Letter of responses for Intake Screening Comments

Permit No: 2012-200
Project Address: 3310 97th Ave SE, Mercer Island, WA 98040
Architect: Robert Edson Swain, Inc.
RES Project No: 1811
Author: Ye Sun

Date: Wednesday, January 27, 2021

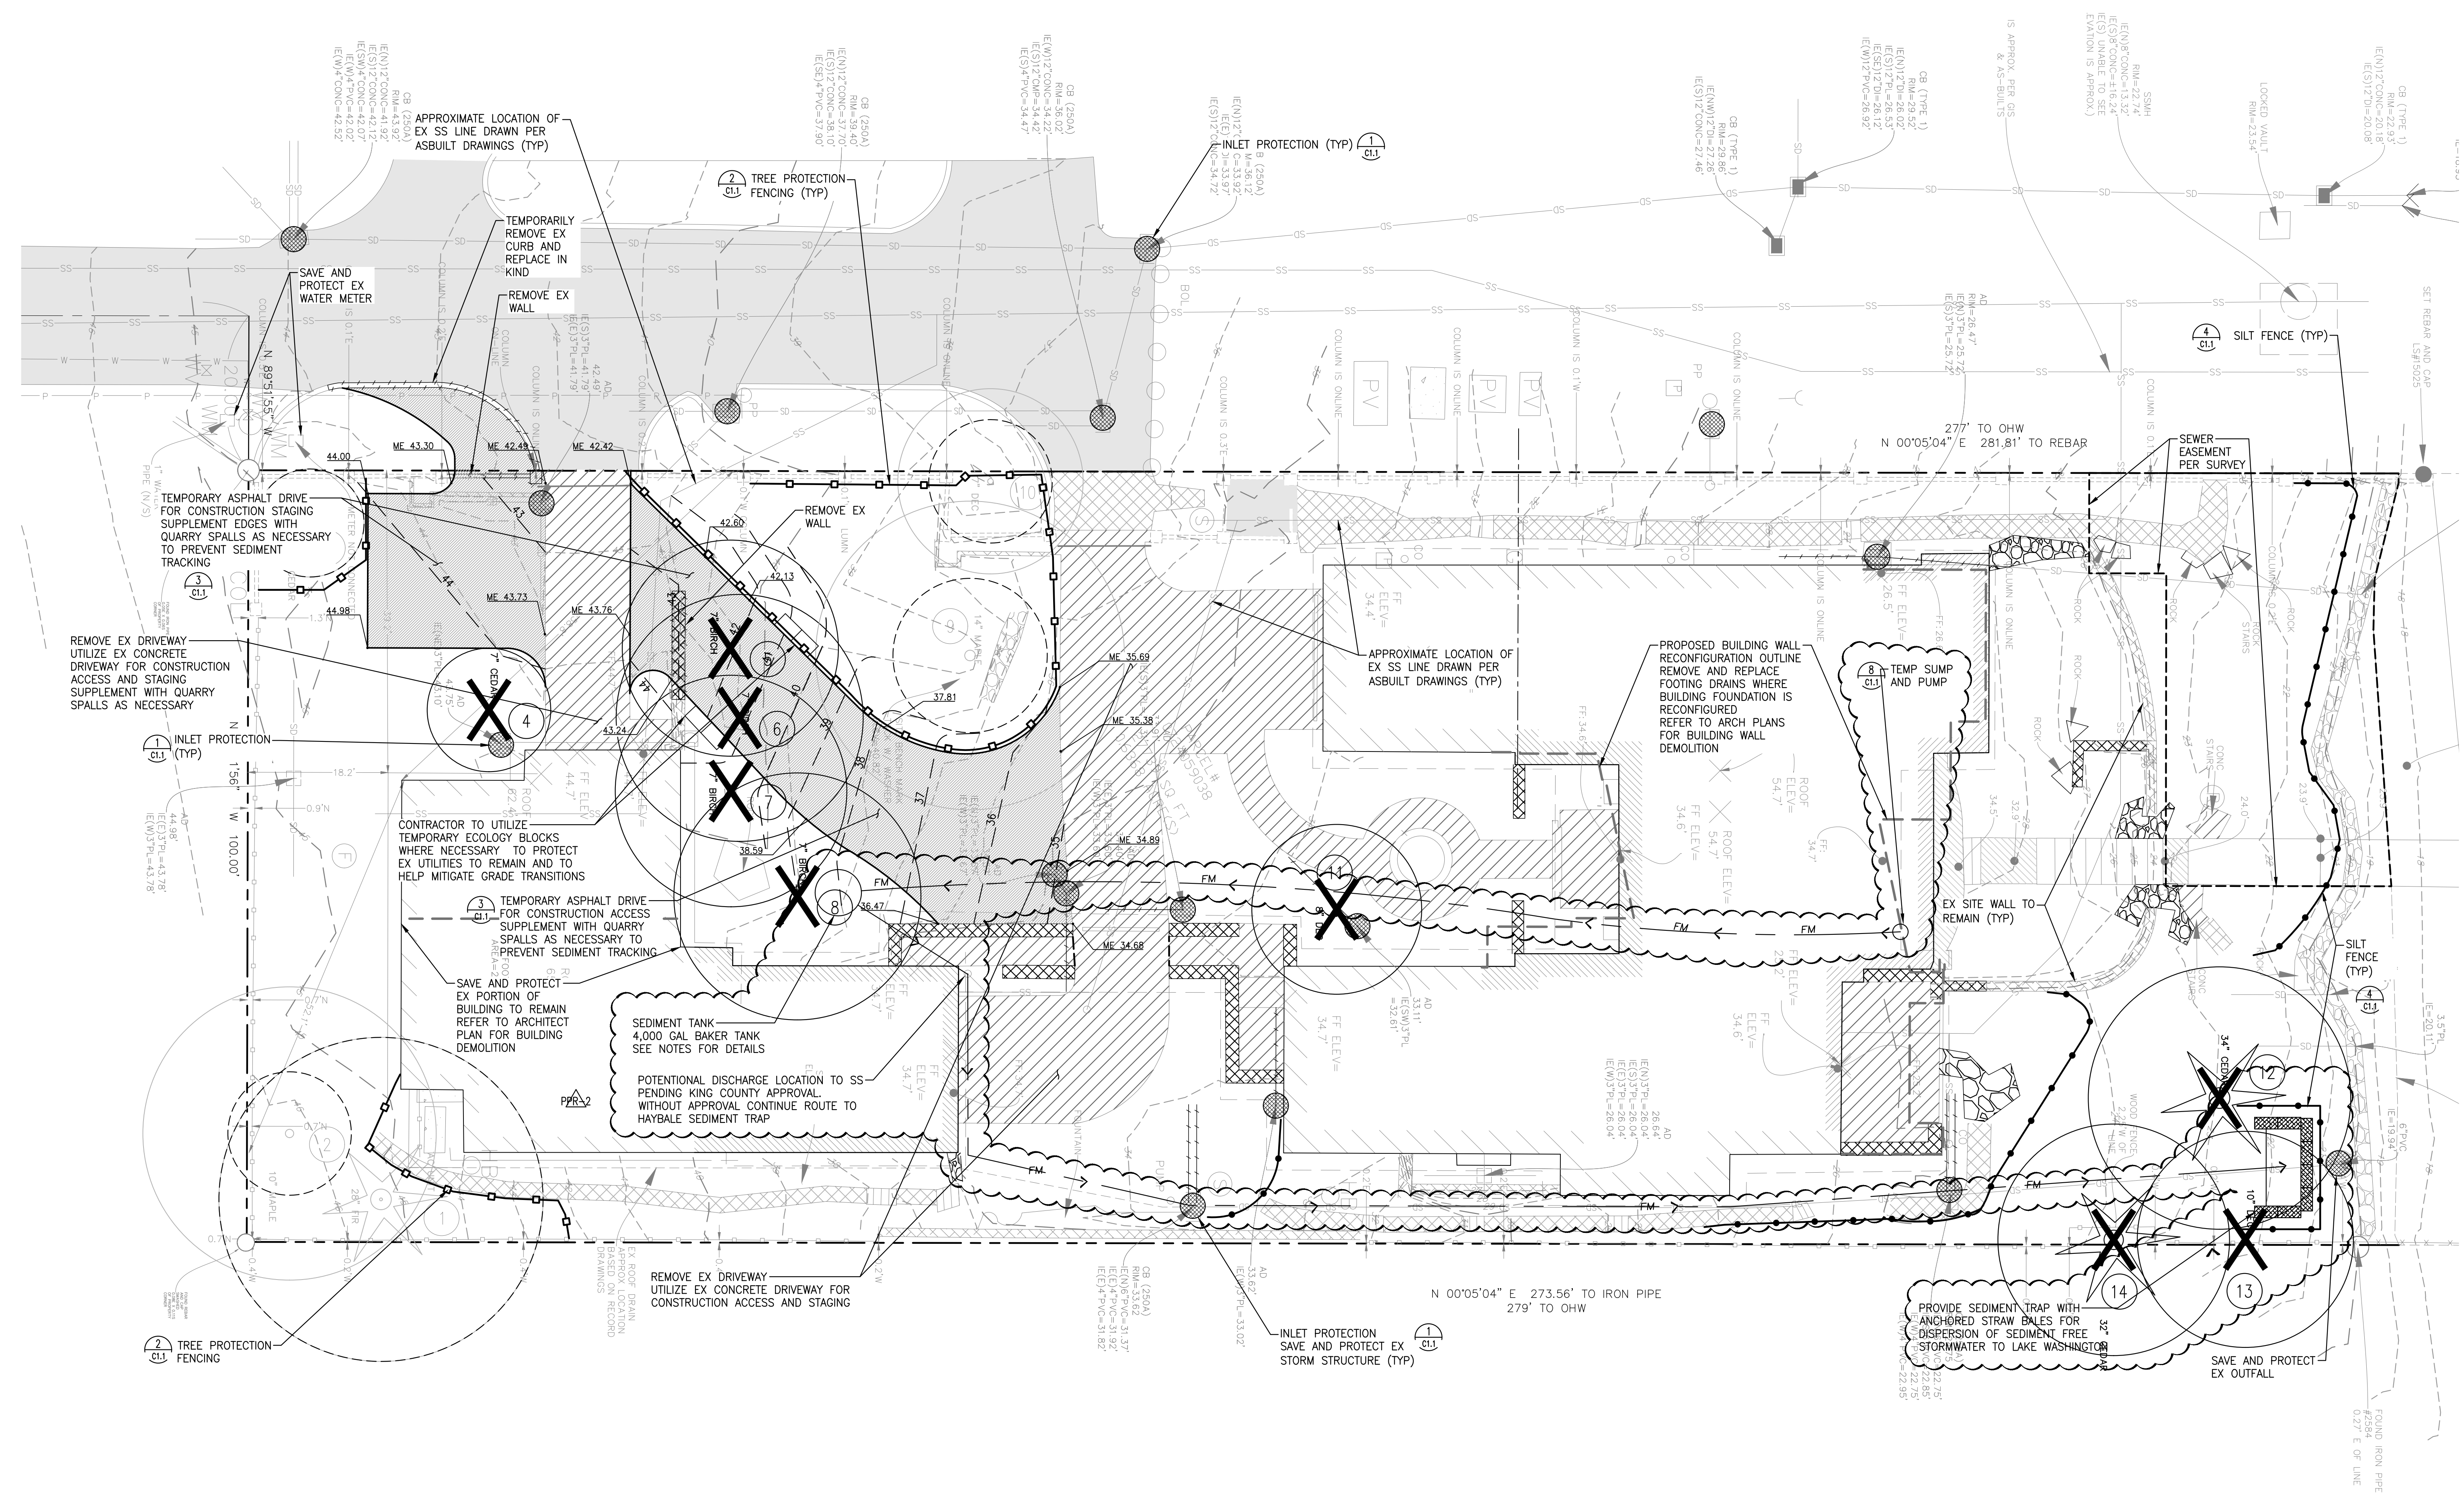
- 6). Construction schedule: File 'L. 2012-200_Construction management plan' in the re-submittal package
 - 7). Erosion Control Plan: Drawing C1.0A in the File '2012-200_permit drawing set' in the re-submittal package

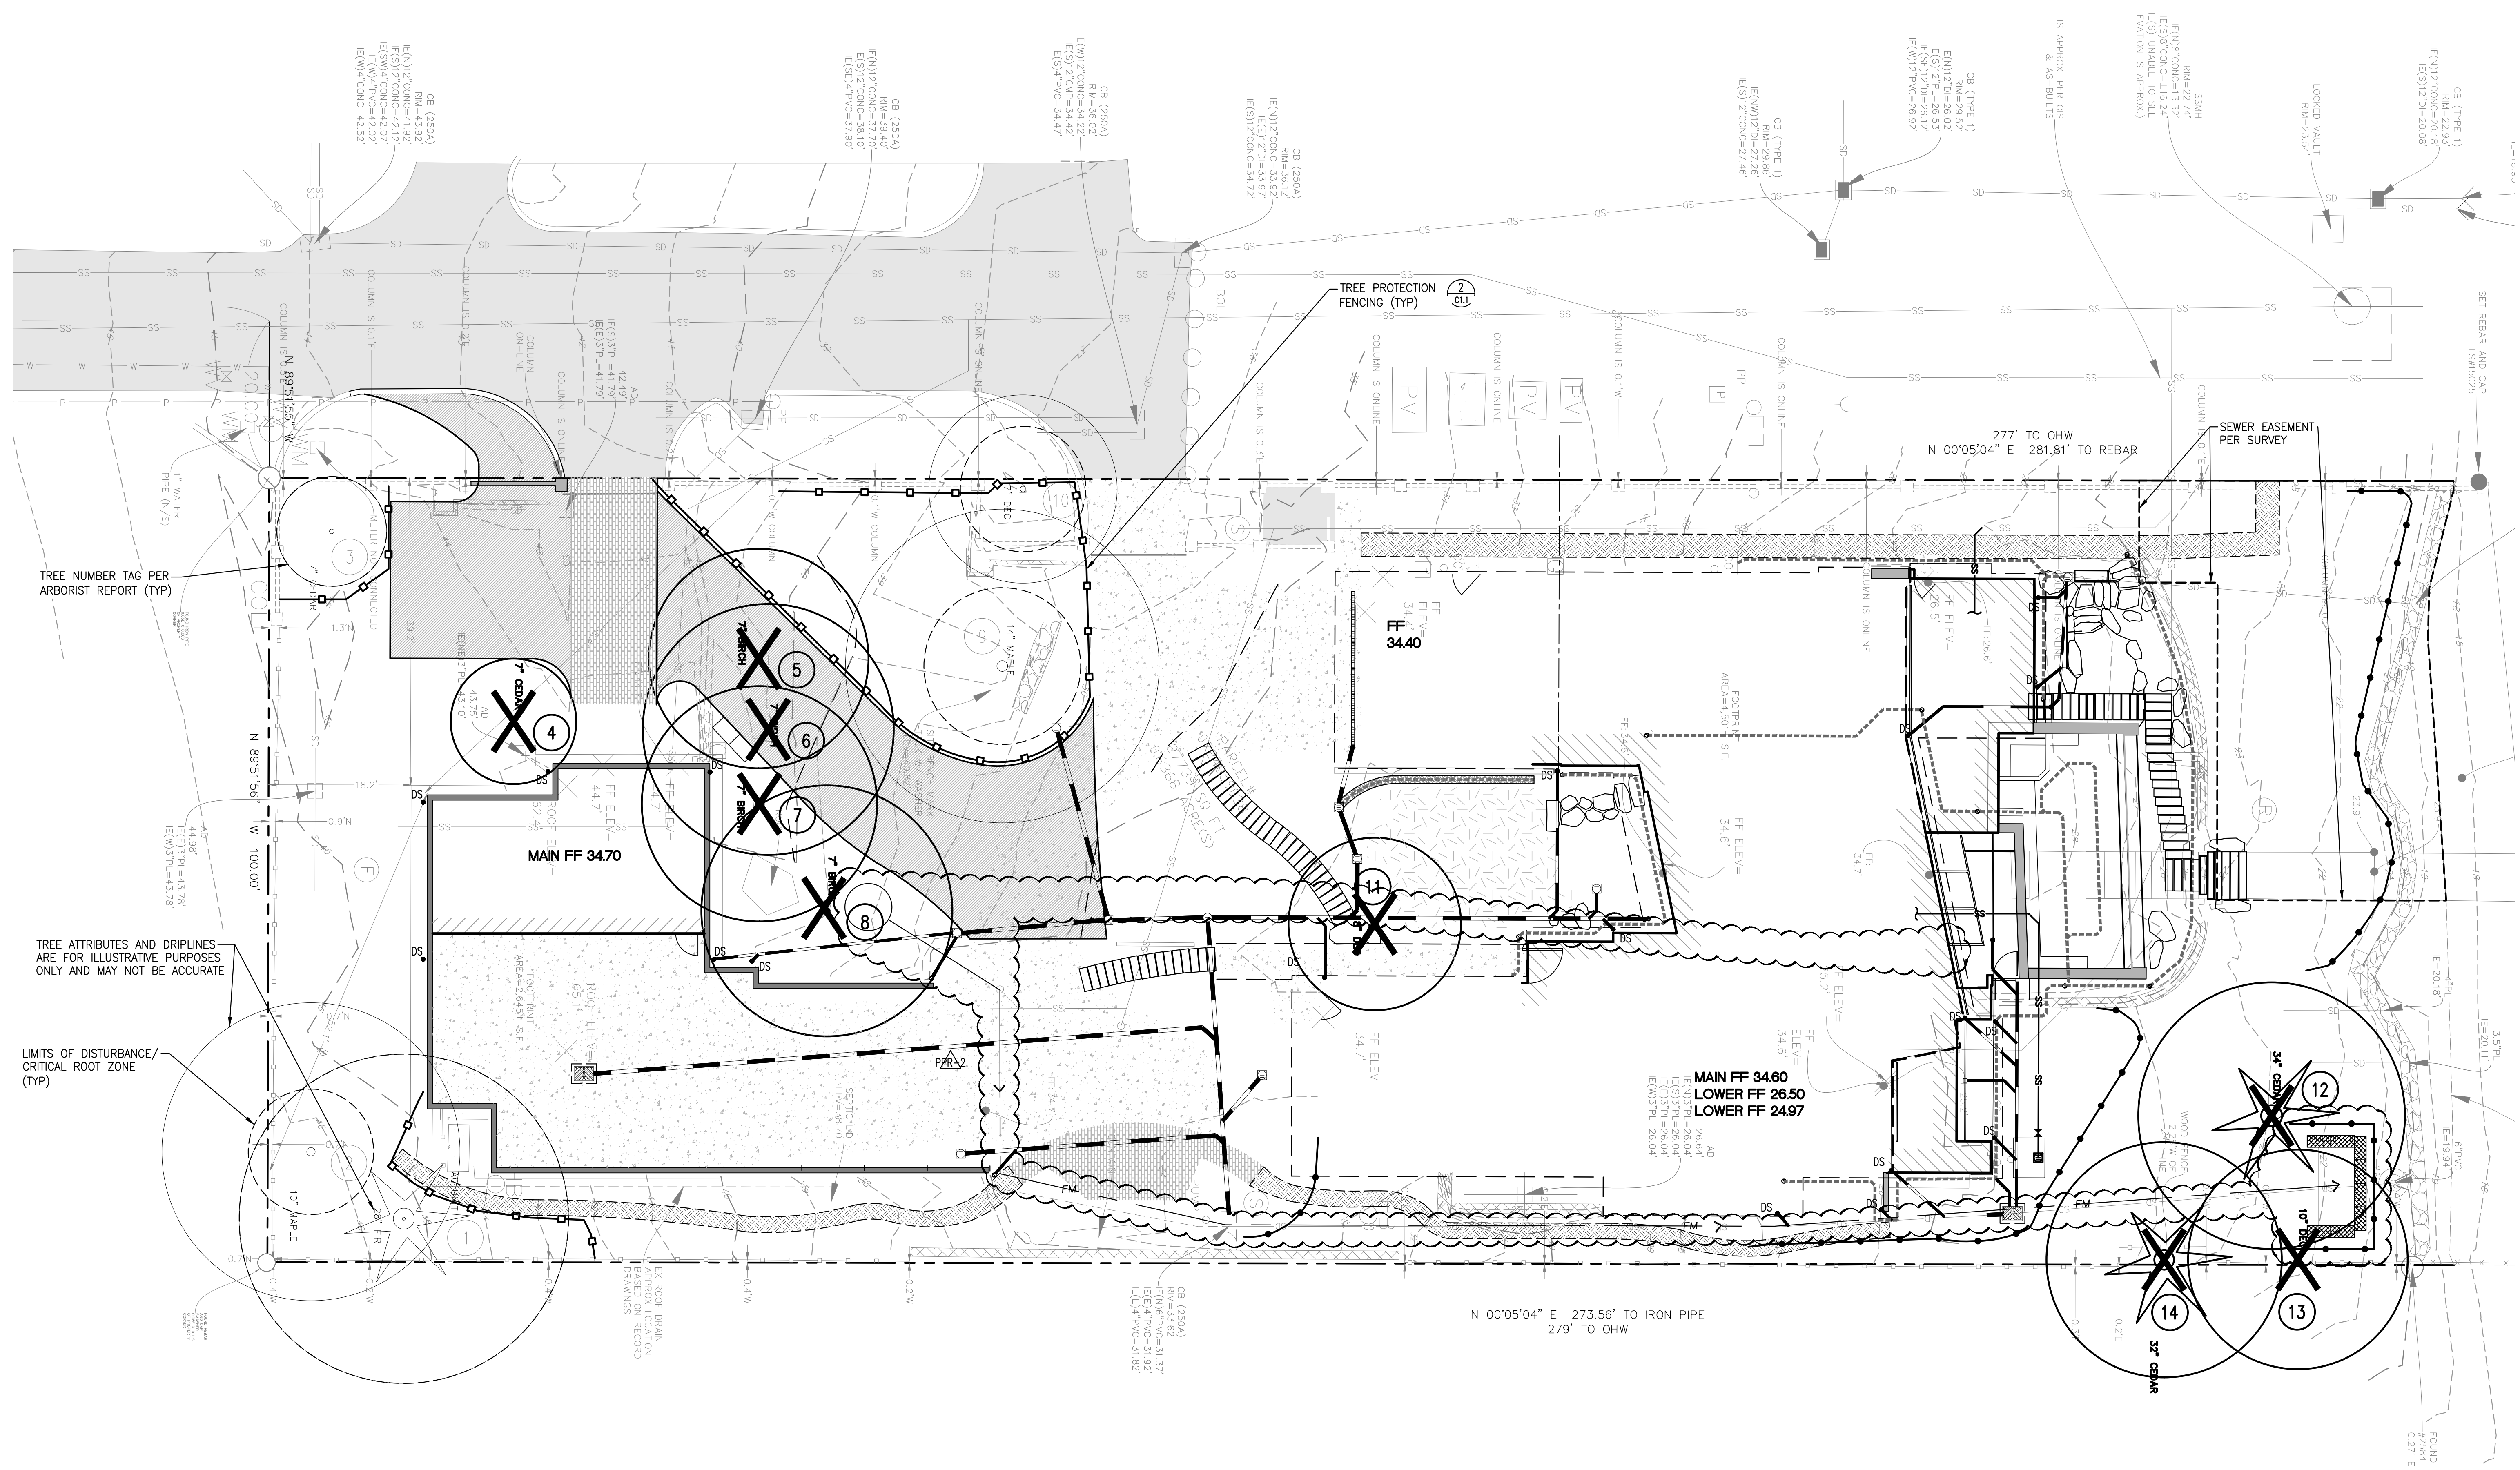
1. Site/Tree retention Plan
Re: See file 'C1.0C Site Tree Retention Plan' in the re-submittal package.
2. Arborist report
Re: See files 'J 2012-200_TreeInventoryReplacementSubmittalInformation' and 'K. 2012-200 arborist report_sig' in the re-submittal package.
